From: Laura Gibbons
Sent: 26 April 2019 11:33
To: 'John Hall'
Cc: Andrew Wood; David Moore - Consulting [REDACTED]
Subject: RE: F/30/18/PL - Drainage comments

Thank you for your comments concerning our application to erect multispan polythene tunnels at Wicks Farm, Ford – F/30/18/PL.

Figure 6: showing plan of the proposed green houses. There is an irrigation water storage reservoir to the north of the green houses, and a plant and personnel building in the south east corner.

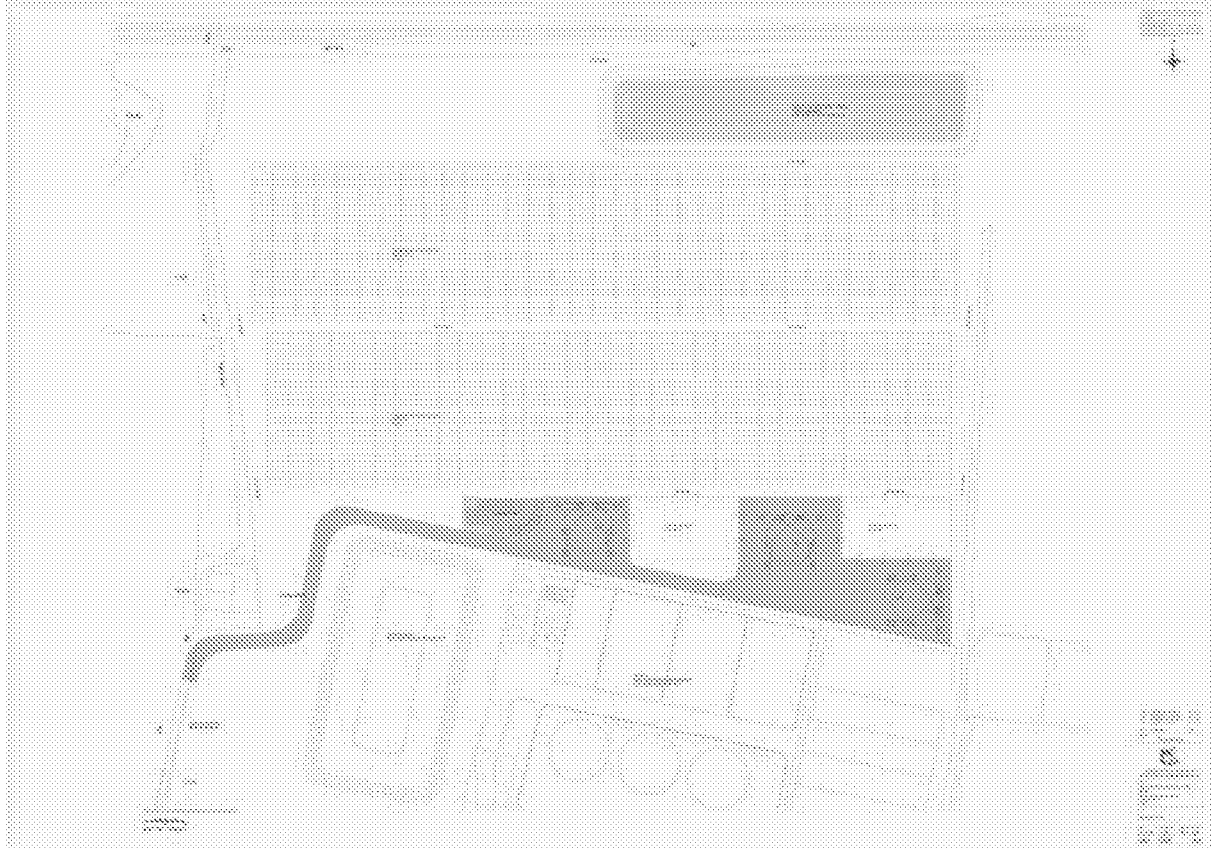
Can you please update the surface water drainage proposals to clearly show this proposed overflow to the ditch system?

And no the information is inadequate, at the minute I have no confidence that the proposals will not increase flood risk elsewhere, including the PRow. Clarification of where the surface water is discharging would be a good start. Proposed levels across the site would also be of benefit.

The Access & Design Statement explains and the technical drawing shows that all the rain water falling on the multispan polythene tunnels will drain North to the new reservoir planned for the lowest part of the field. An overflow system will be designed to take surplus water to the existing local ditch system and onward directly to the River Arun.
